Recommendation Report

AW/5/13

New barrel vault roof light, new marley cedar weatherboard cladding, soffits and fascias, re-arrange position of existing rooflights and repairs to existing chimney (additions to previously approved planning permission AW/140/10/)

33 Aldwick Avenue Aldwick

DATE Aug 12	DRAWN AS	CHECKED -
JOB NUMBER 3106	DRAWING NUMBER PR12	REVISION

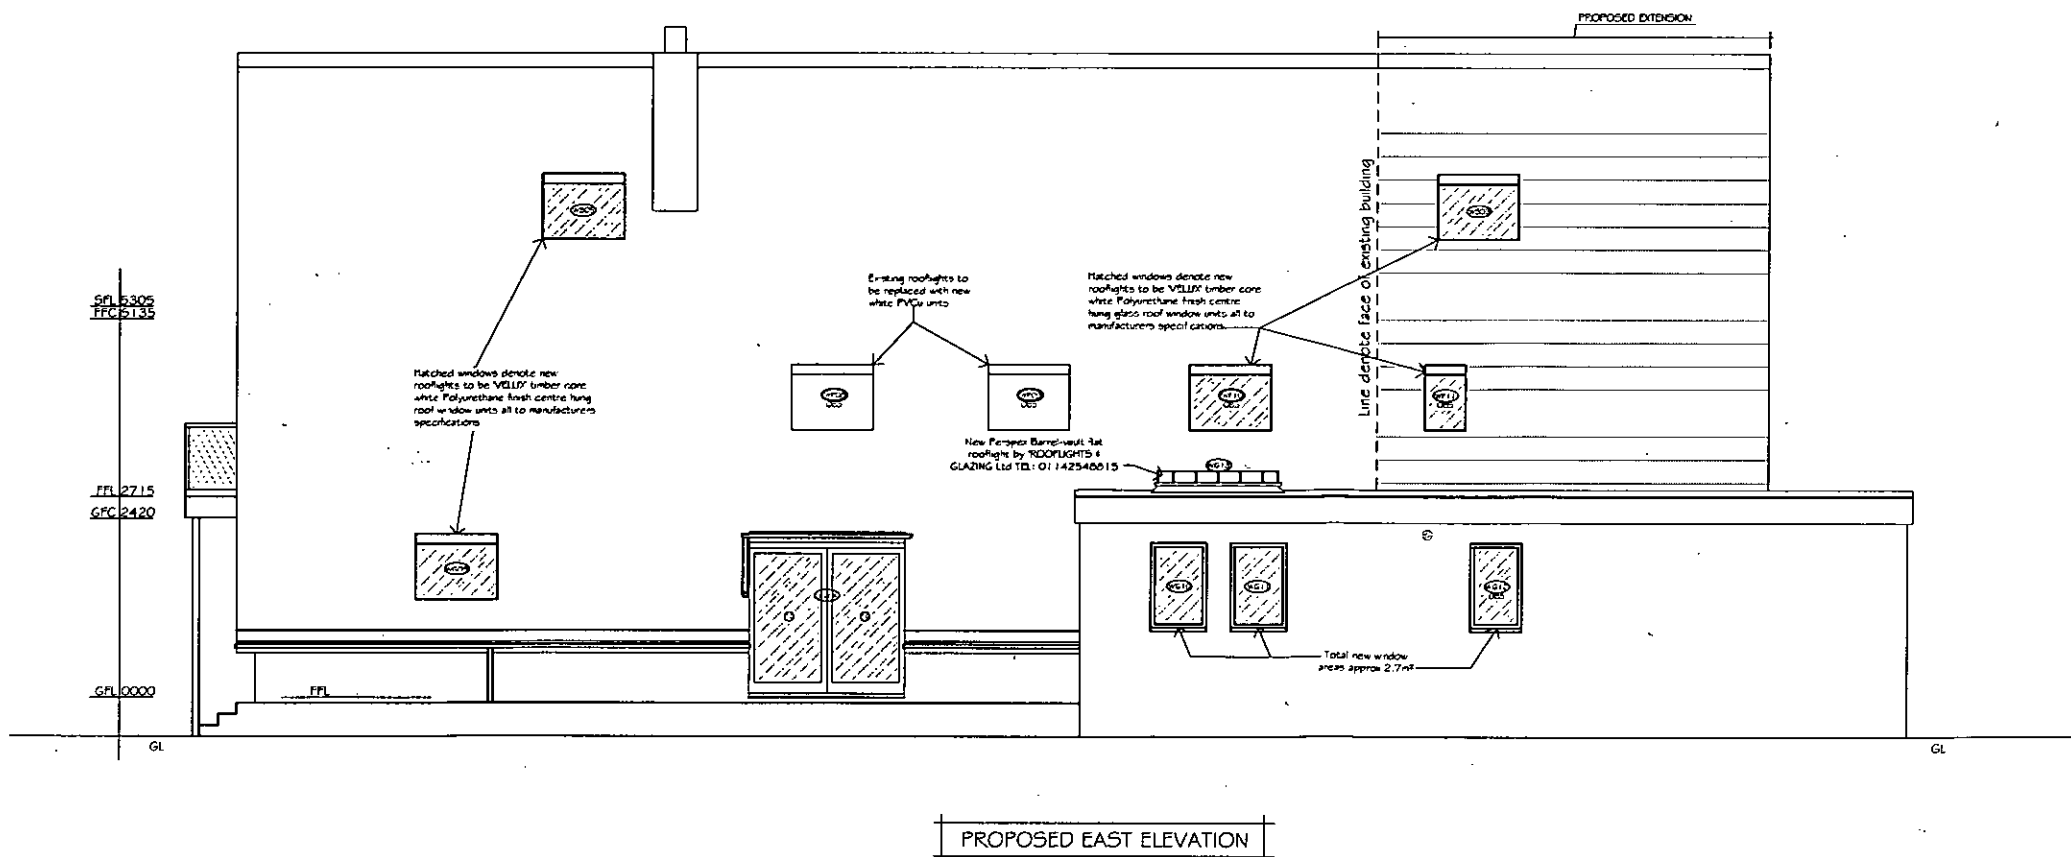
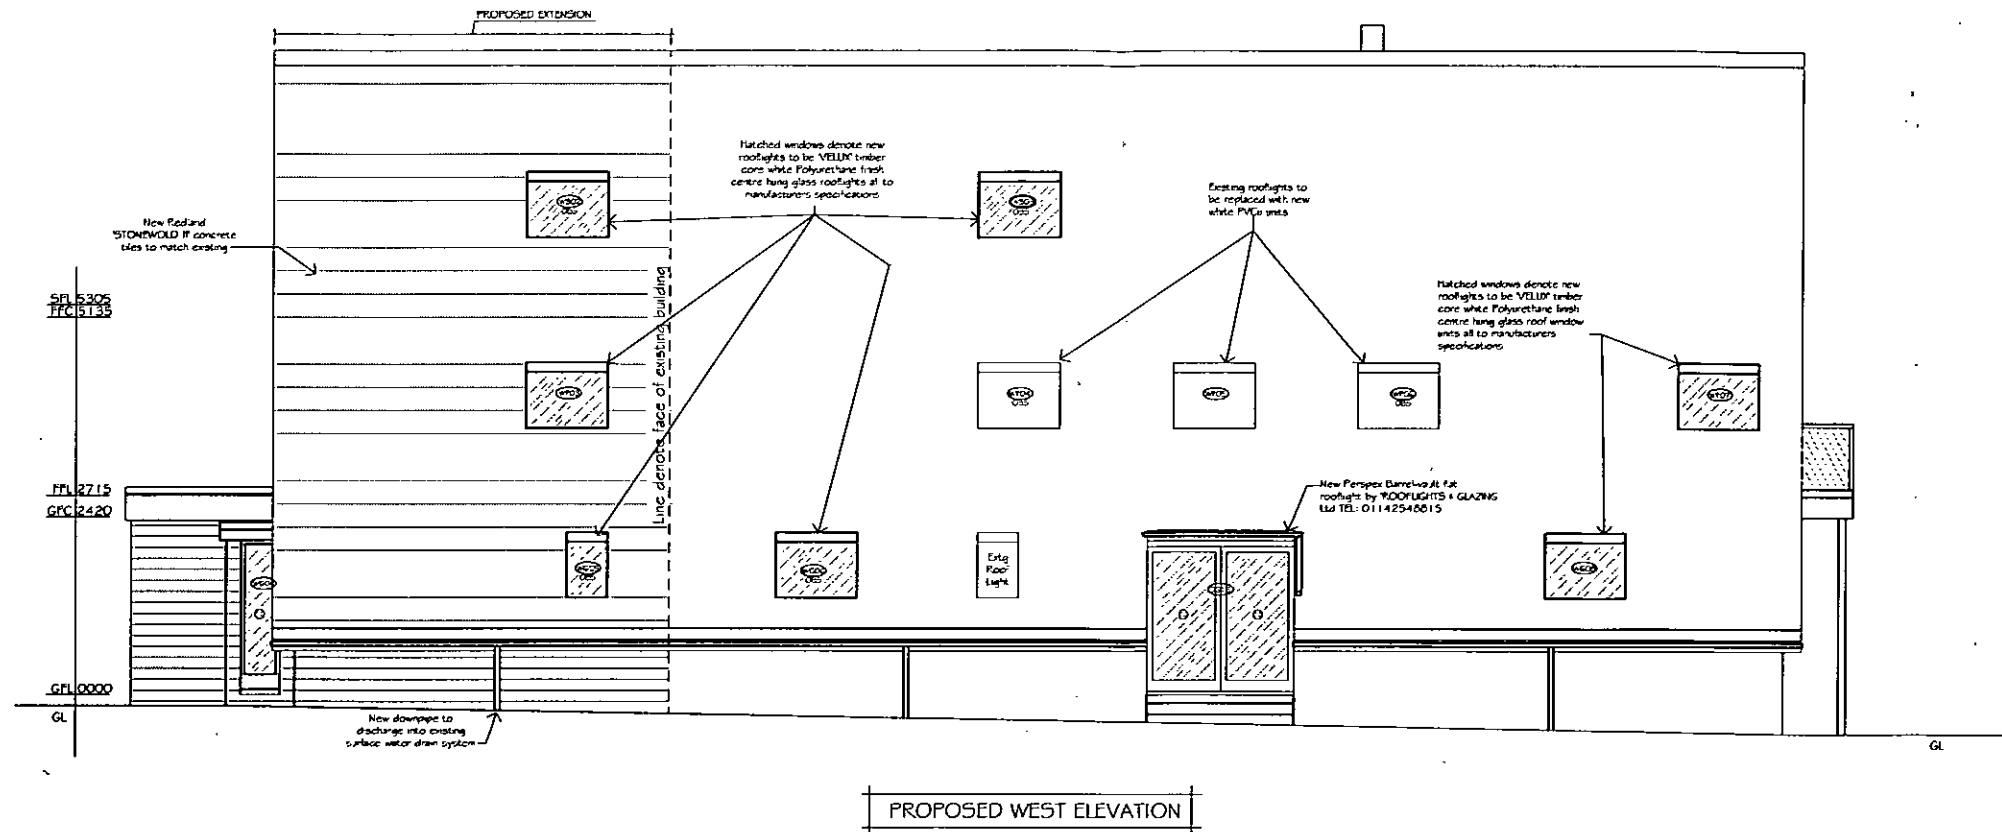
With regard to the enquiry concerning a height of 1.7 metres this appears within paragraph 7 Residential Amenity of the conclusions of AW/140/10. This appears to require that planning permission would be required for any opening roof light should it be more than 1.7m above interior floor level. This would include the top or head of any proposed window and therefore is not solely applicable to cill level and there appears to be no requirement for any window sill to be above 1.7 metres.

Further to our telephone conversations today please find attached our drawing PR12 which details the proposed Velux roof lights and those to be 'obscured' denoted by OBS on the East and West elevations.

On the East elevation these windows are WF08, WF09, WF10, WF11 all on the first floor and WG12 to the ground floor.

On the West elevation the obscured roof lights are windows WS02 and WS03 on the second floor, WF04 and WF06 on the first floor and WG05 and WG06 on the ground floor.

Some of the proposed windows will have the top of the roof lights above 1.7 metres and the new roof lights will therefore form part of the current application under AW/5/13. Those to be obscured are detailed above and as per the attached drawing.
